Ribble Valley Borough Council
Planning Section
Council Offices
Church Walk
Clitheroe
BB7 2RA

Planning Application No: 3/2024/0542

Location: 91 Ribchester Road Clayton le Dale BB1 9HT

Amended plans have been submitted for the above application. The following comments are made in addition to the highway authority's responses dated 1 and 13 August to the original submission.

Drawing Title
Proposed Site Plan

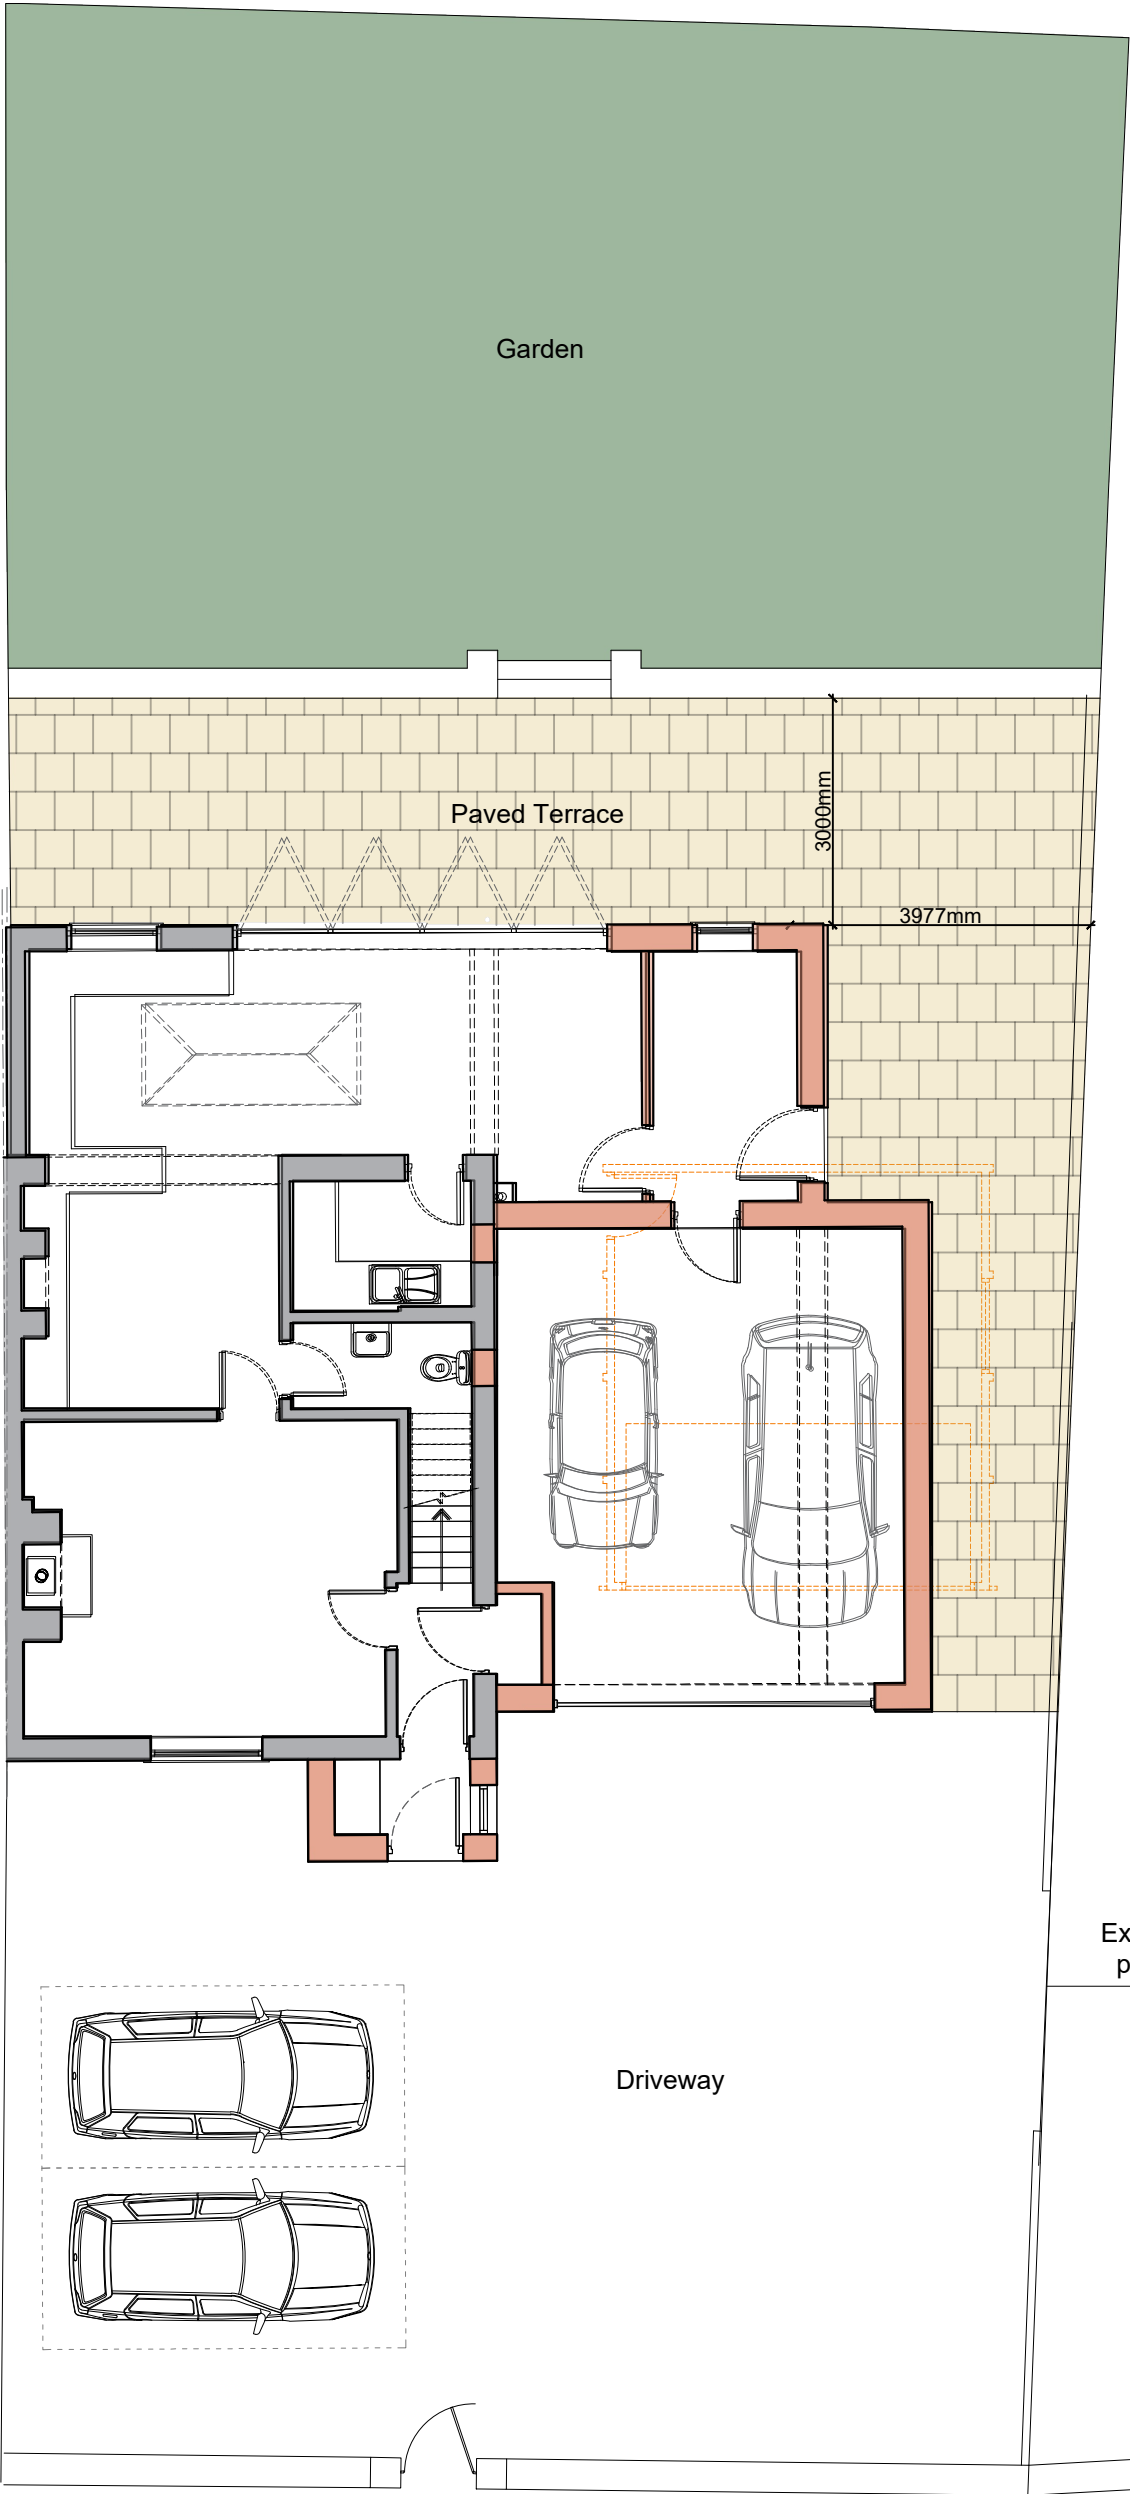
The proposed amended scheme with regard to retaining the existing vehicular access via the grounds of the memorial hall conflicts with the scheme for Salesbury Memorial Hall approved under planning permission ref 3/2023/0144. 1.5m wide internal footways with full height kerbs have been approved on both sides of the internal drive. Retaining the existing vehicular access to No 91 would require the provision of dropped kerbs and a properly constructed vehicle crossing over the footway. An application has also been approved recently at the memorial hall for the installation of illuminated bollards along both internal footways (ref 3/2024/0479). The construction of the dropped vehicle crossing may also conflict with the approved scheme for these bollards. Consequently, the retention of the existing access point may require the memorial hall to submit planning applications to vary plans approved under both the above-mentioned planning permissions.

The highway authority would not support the loss of off-road parking should the memorial hall not wish to submit further planning applications as described above to allow the continued use of the existing vehicular access.
